Demolition of existing dwelling & the erection of 7No. residential dwellings, with associated parking, amended access location from Lime Tree Close & landscaping.

Scorton 9 Lime Tree Close East Preston

Thank you for your internet representation made on 28th April 2018 which has been recorded as **'an objection'** with the comments as follows:

Drawing ref: LTC.PLOT7.001

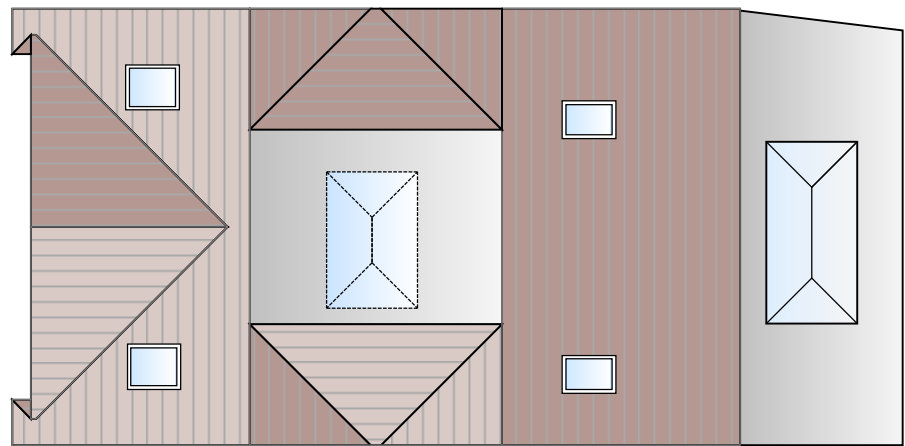
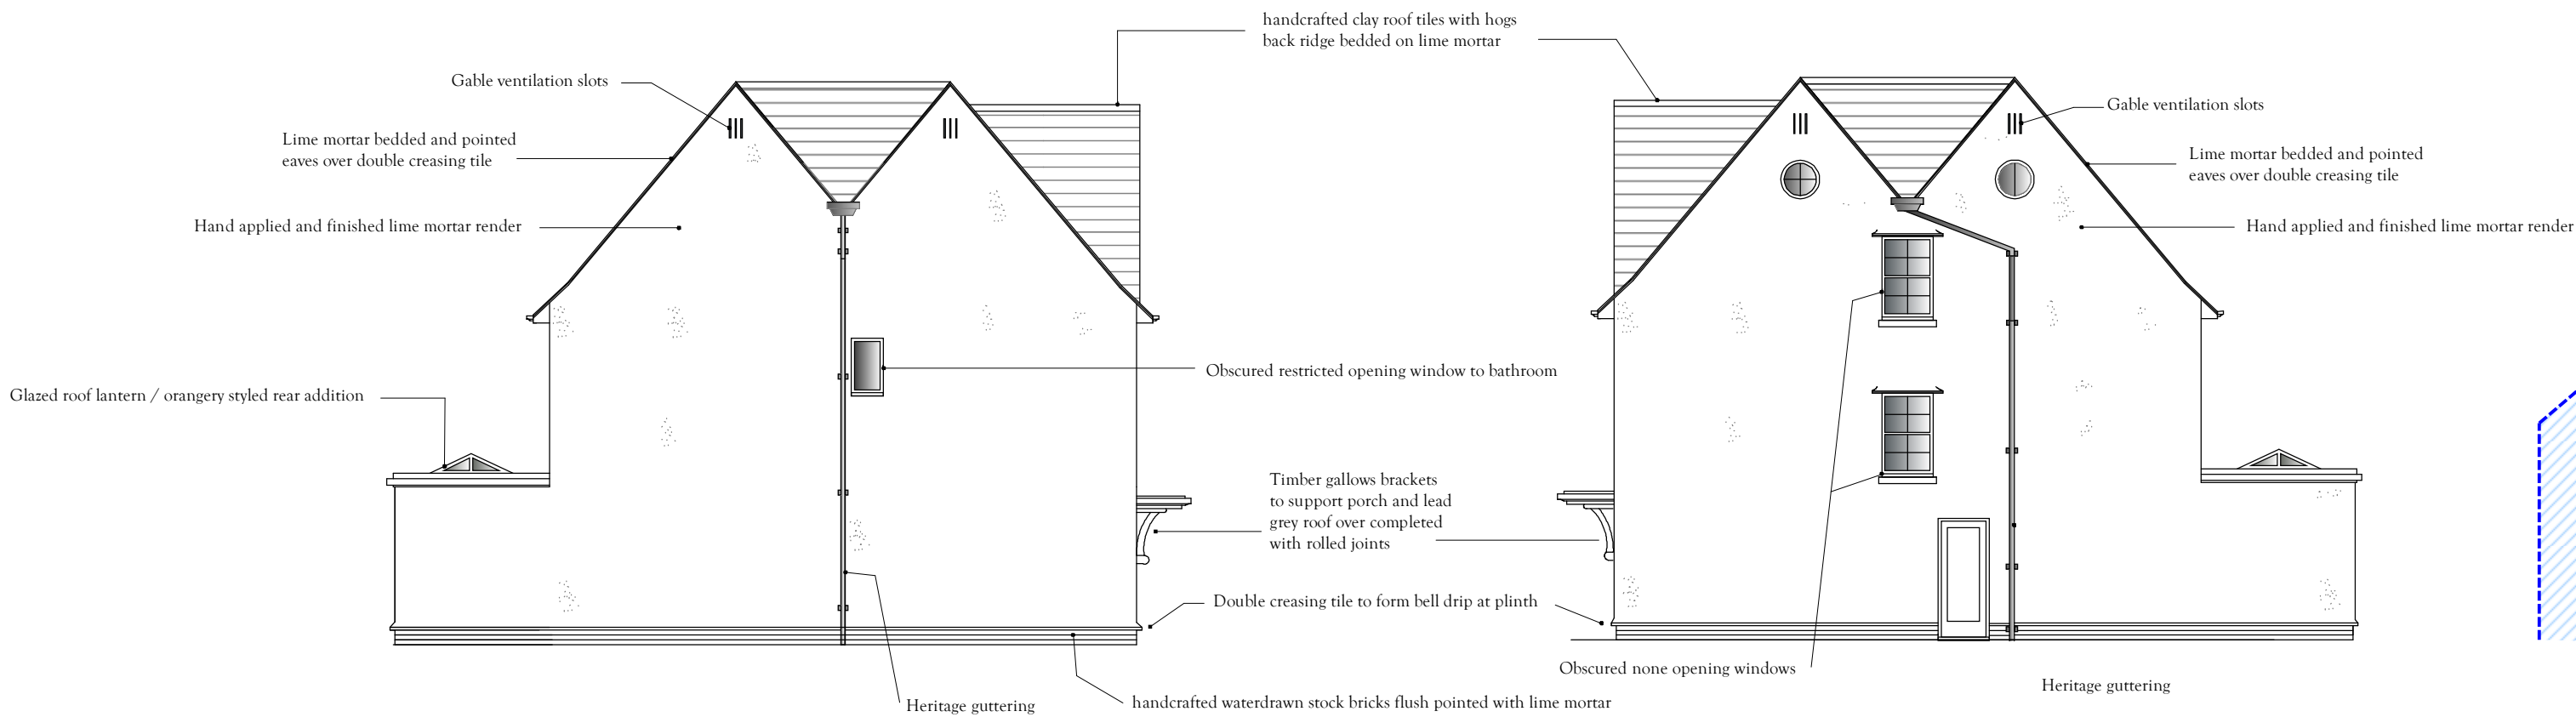
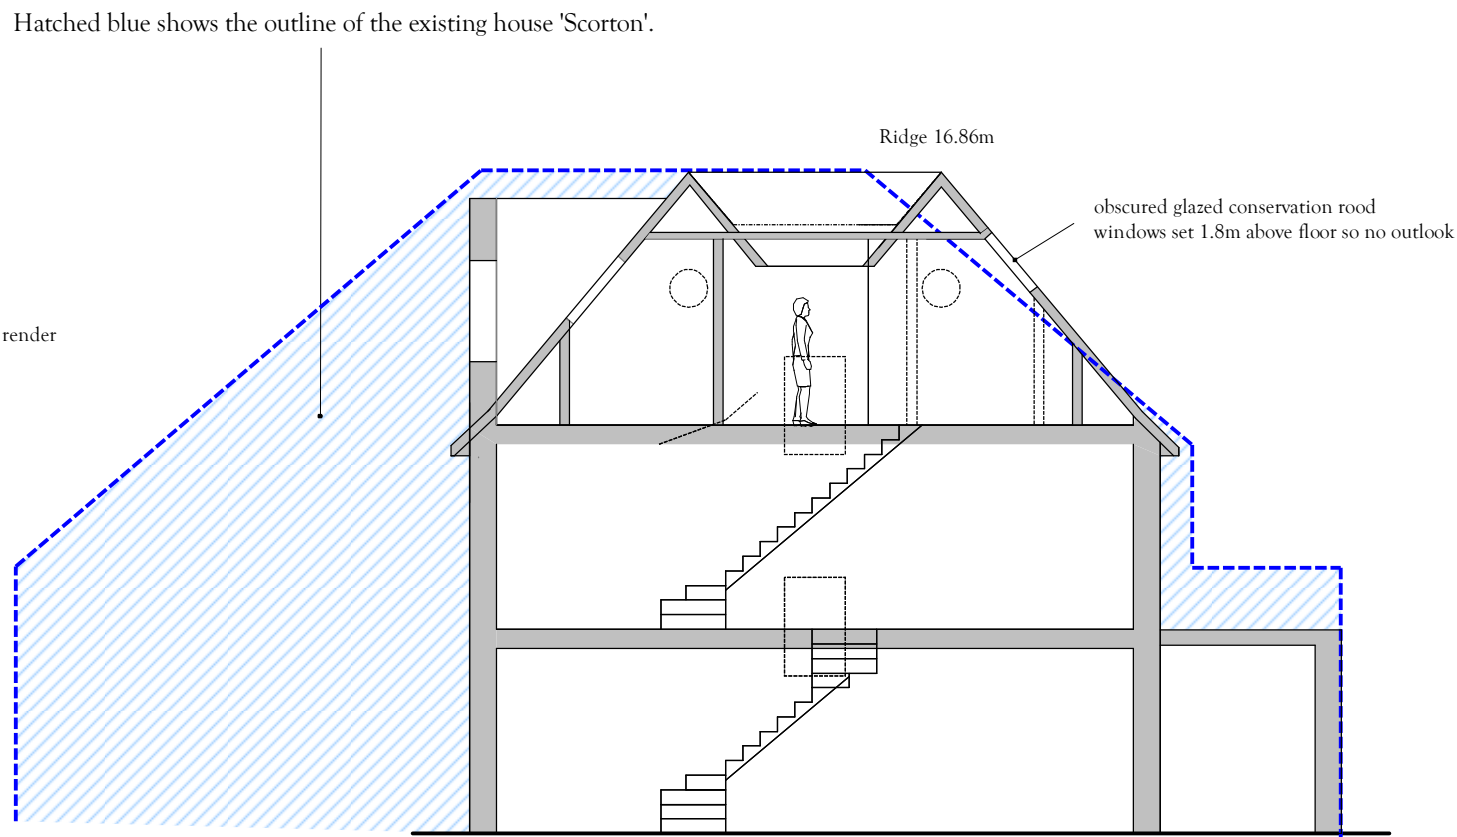
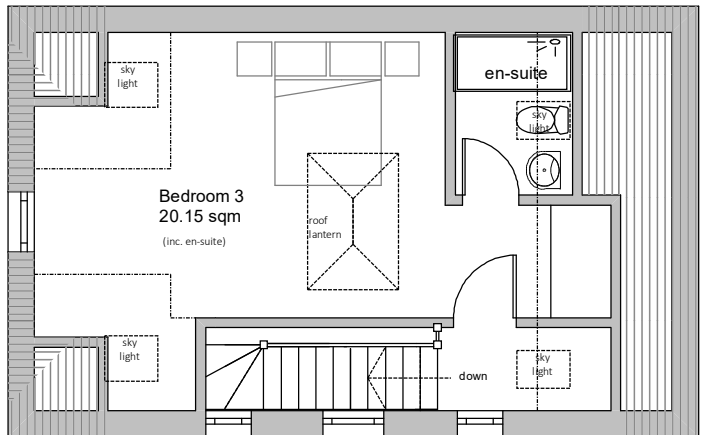
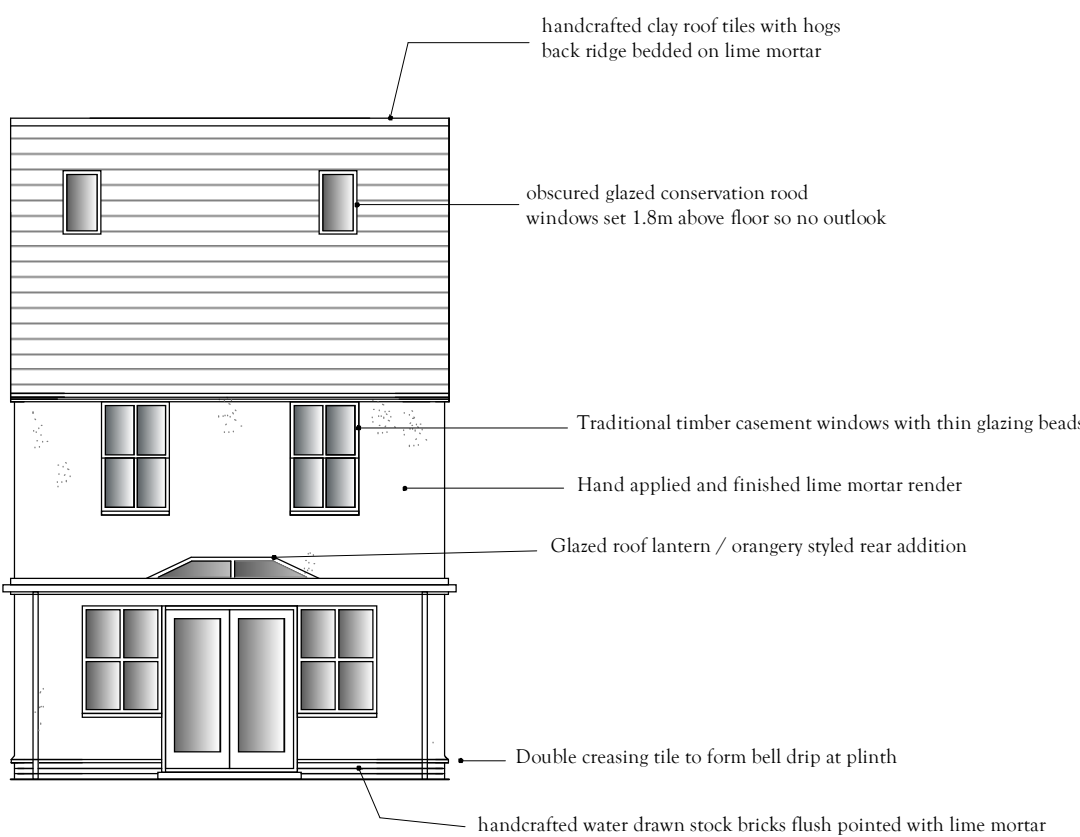
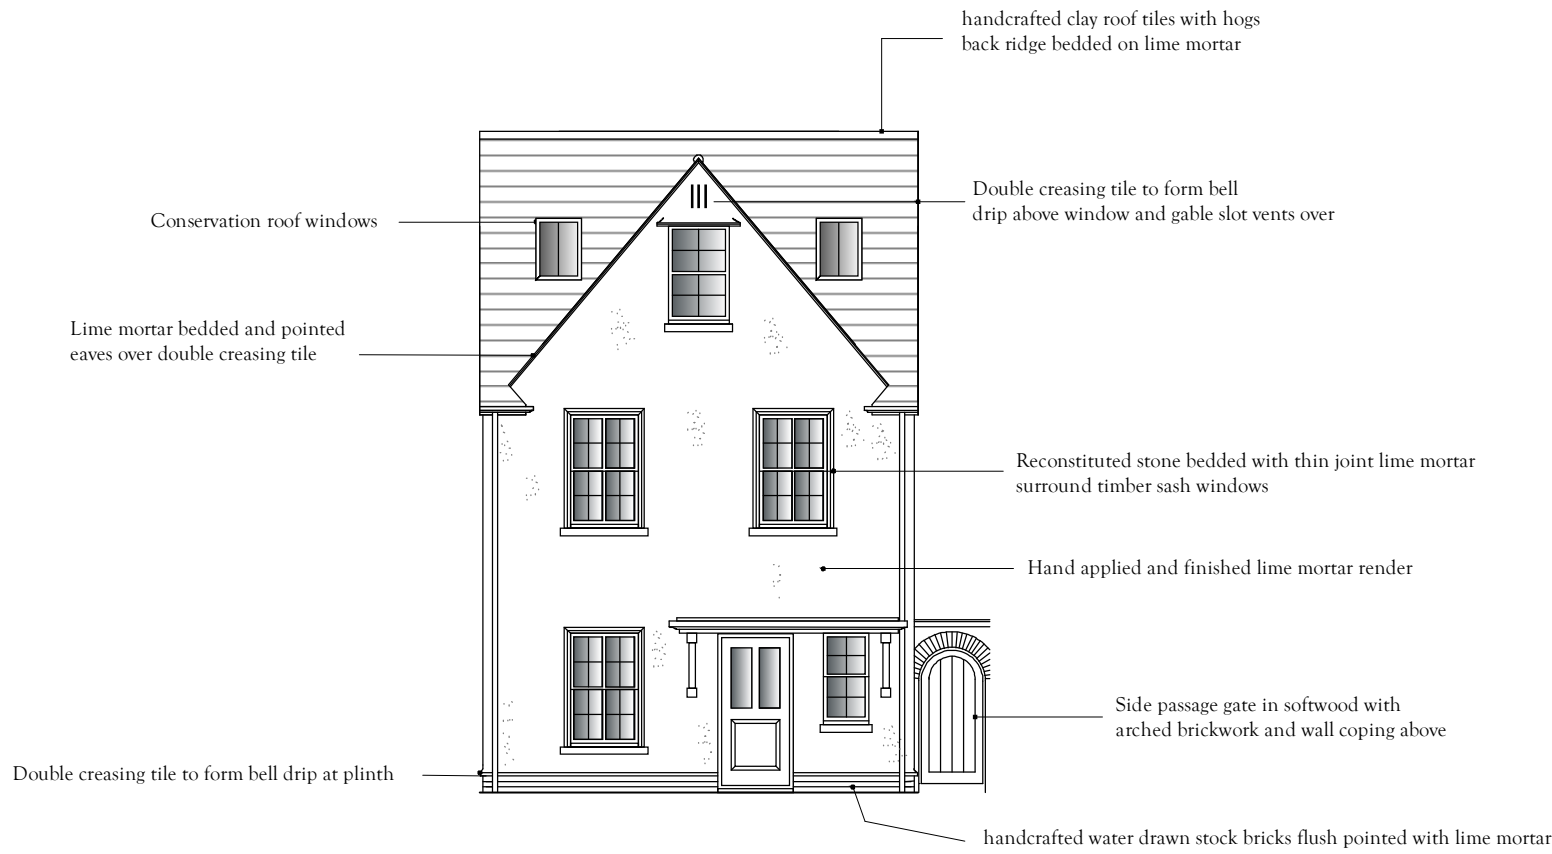
Comment 2. We note from the wording on the plans that the developer assures us the proposed new houses will be the same distance away from the boundary as the existing house, and be the same height. However - the plans show three storey houses with windows in the roof level. Currently our rear garden is not overlooked by the existing old house yet this proposal seems to show a row of four new houses with 2nd floor windows able to look down on us.
